Our Ref: R/2023/1/B
File No: 2024/038838
Your Ref: SSD-53386706

SSD-53386706 – Environmental Impact Statement – Bank Street Park

Thank you for your correspondence dated 13 December 2023 inviting the City of Sydney (the City) to comment on the abovementioned State Significant Development Application.

Title  
GENERAL ARRANGEMENT PLAN  
HARBOUR PARK

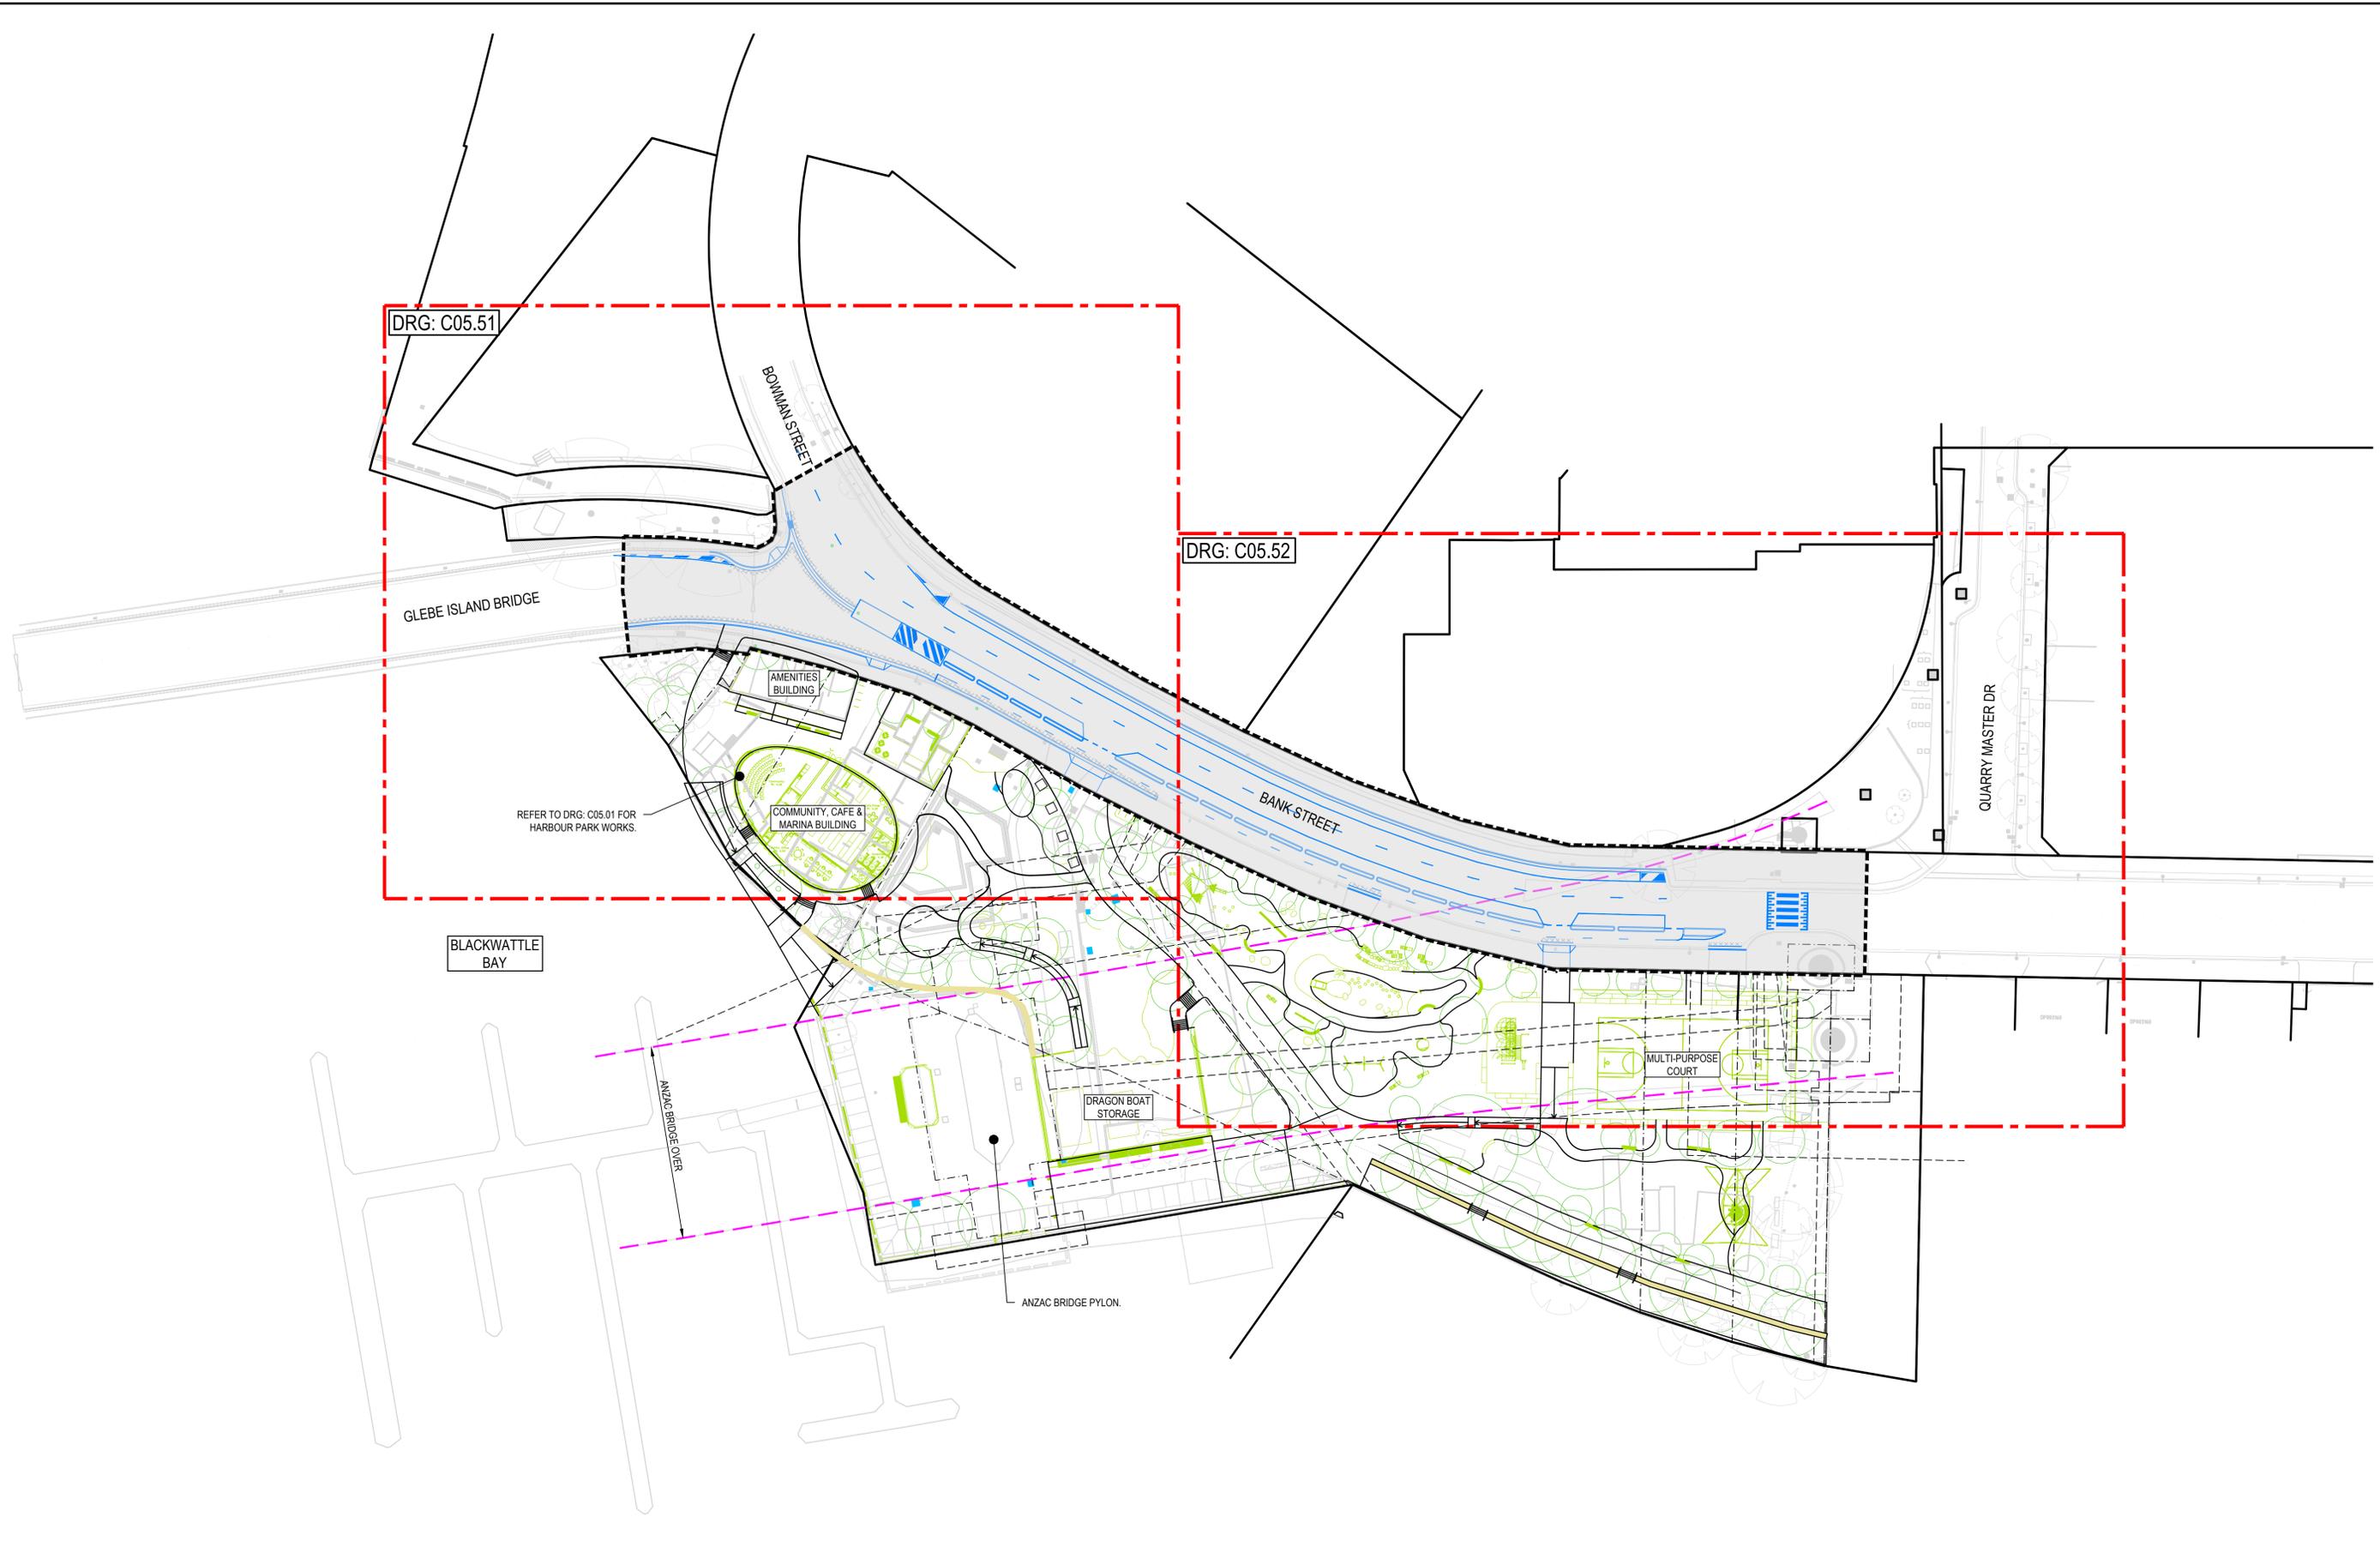
- DAC01.41/2 – A long section X-X through the centreline should be provided for each access to the site. The section should include the existing and proposed levels and must indicate the property boundary.
- DAC01.41/2 – A new kerb ramp shall be located across the road from the proposed ramp along the new blister.
- DAC01.41/2 – All existing vehicular crossings are to be included in the plans. It appears that the driveway to Building D (13 Bank Street) has not been included.
- DAC05.01/2 – The proposed levels at the northern corner of the proposed amenities building may require revision to ensure the footpath slopes towards the kerb.

Project Number/Drawing Number  
**220067-00-DA-C05.01**

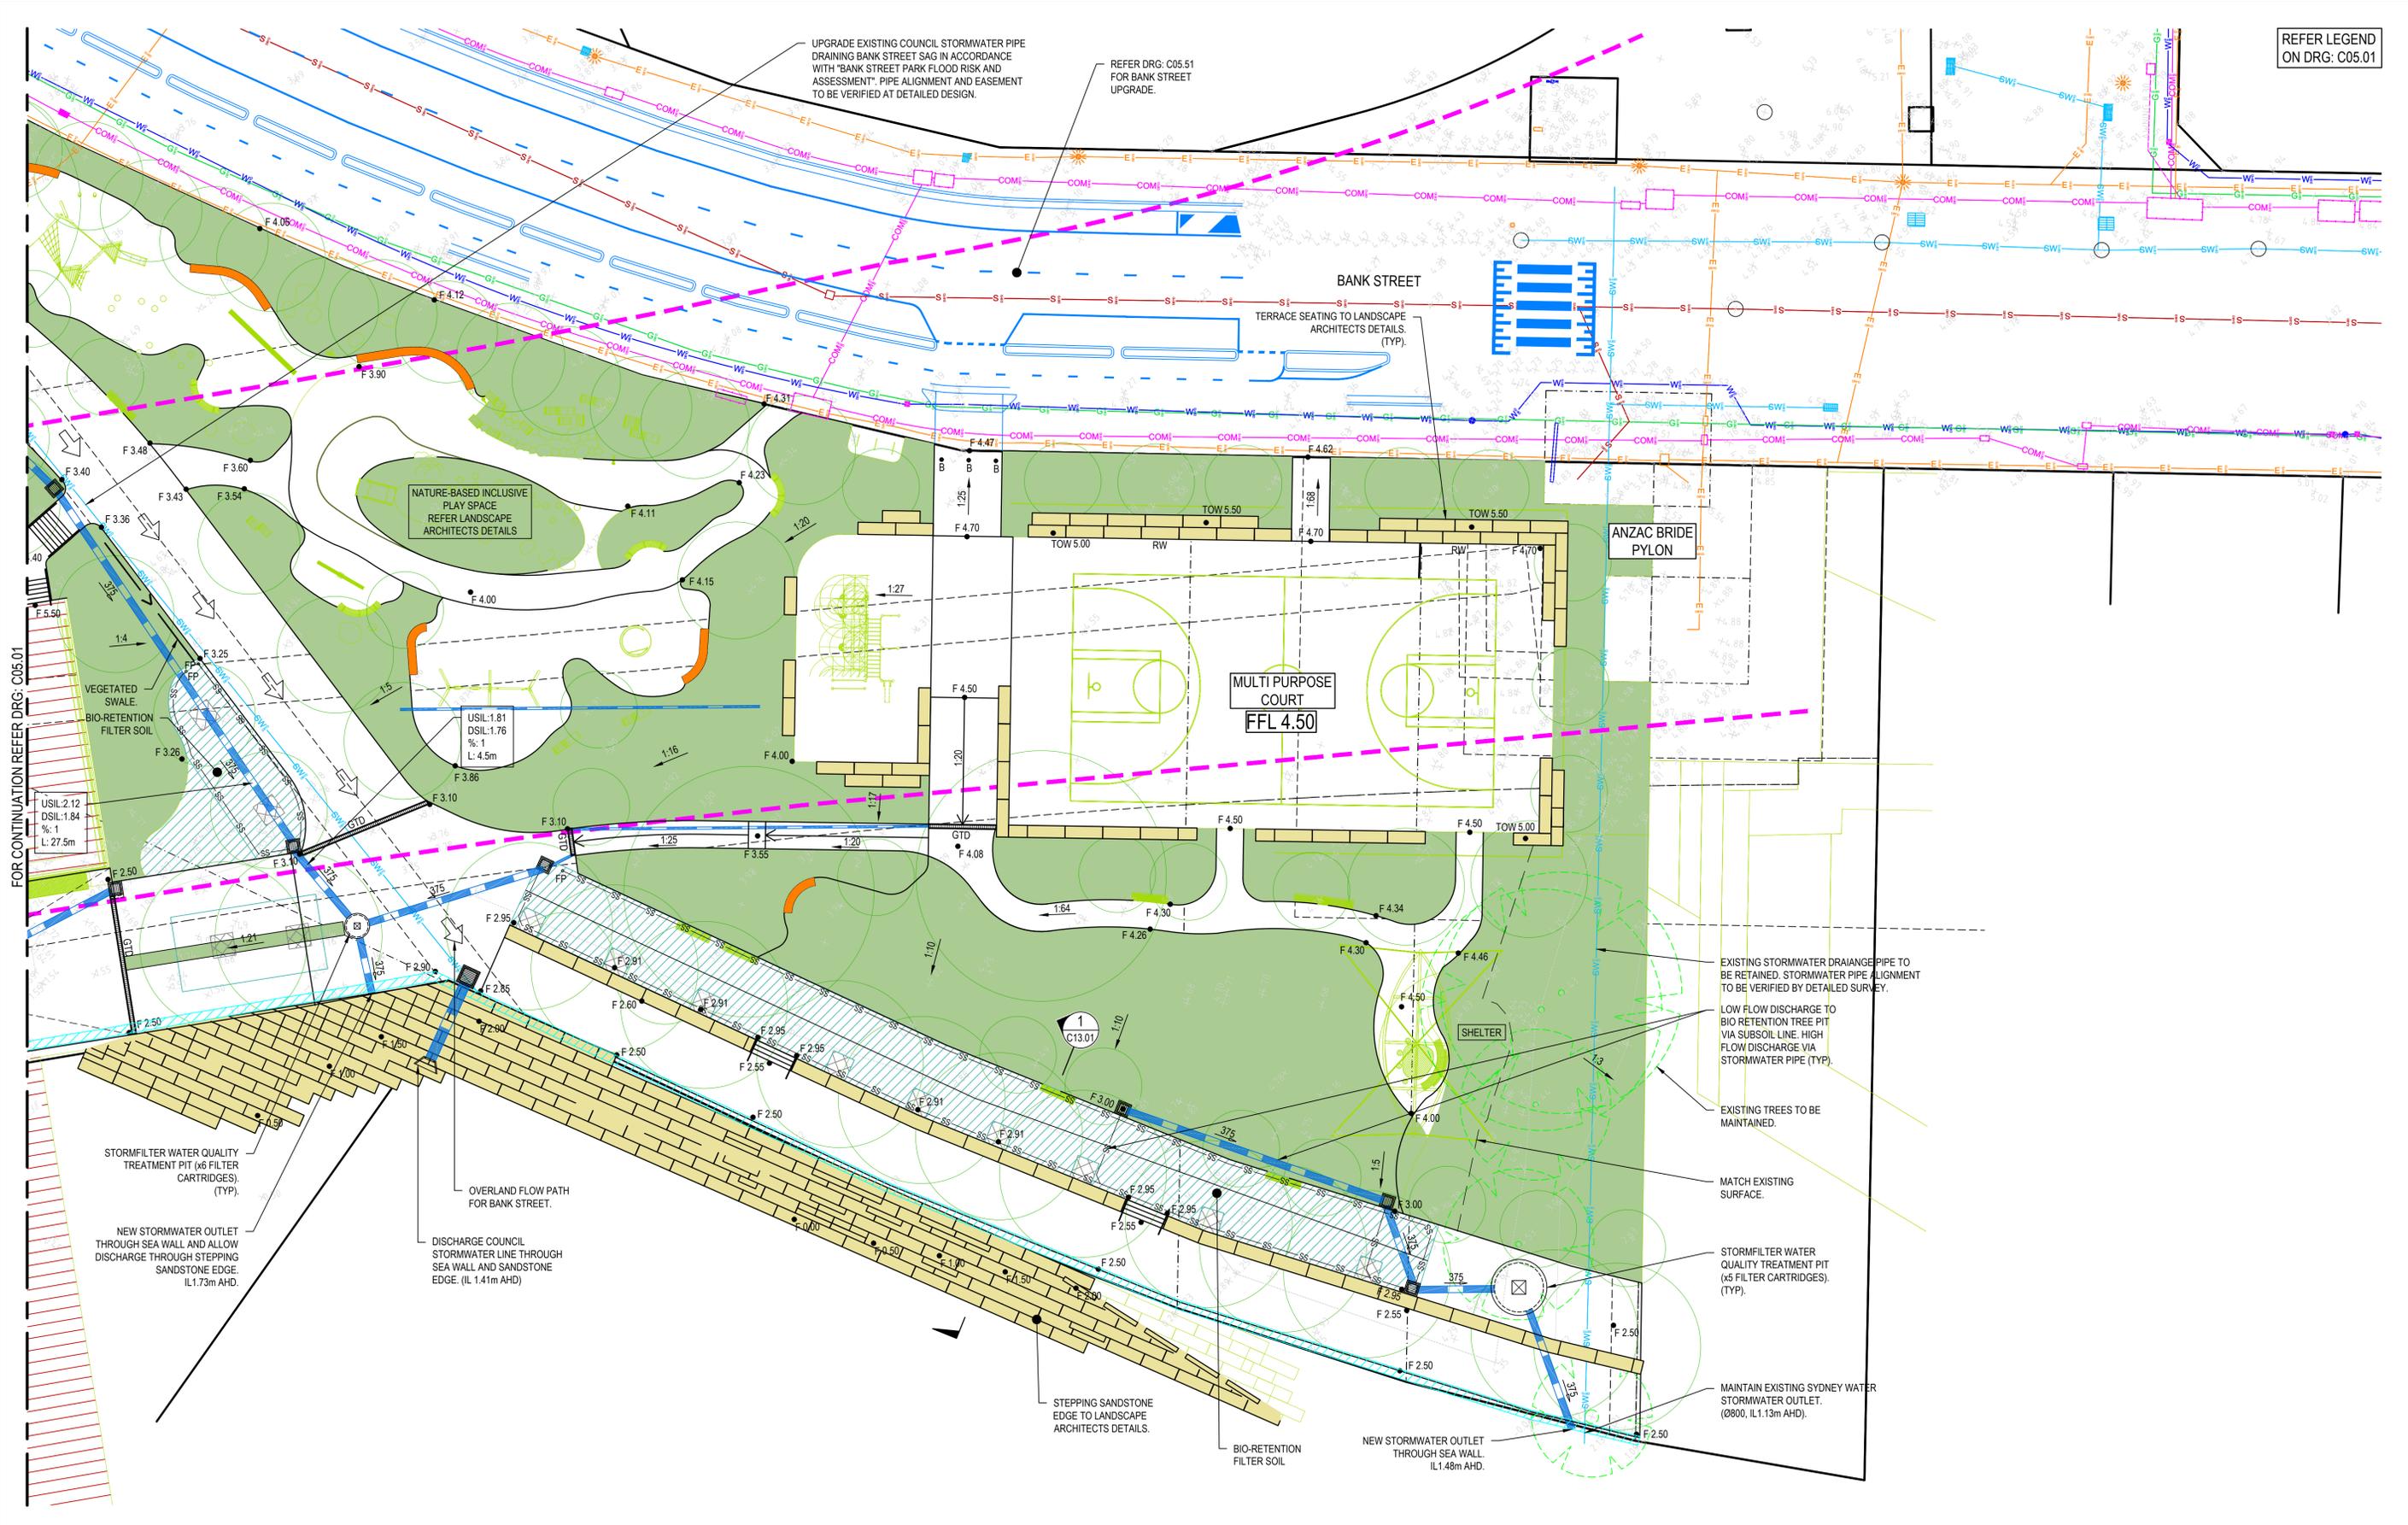
- DAC05.02/2 – The existing drainage line, located adjacent to 21-29 Bank Street, is part of the City's stormwater system. A future drainage easement area must be included in the application. The size of the pipeline determines the width of the required drainage easement. Therefore, the location and the diameter shall be surveyed to ensure that the proposed structures, including footings, are located outside the zone of influence. Refer to the City's Sydney Streets Technical Specifications A4 STORMWATER DRAINAGE DESIGN Table 6:
<https://www.cityofsydney.nsw.gov.au/design-codes-technical-specifications/sydney-streets>

- DAC05.02/2 – Any new internal drainage shall be located outside of the City's drainage easement area. Adjusted location of the proposed internal private drainage must be indicated in the plans.
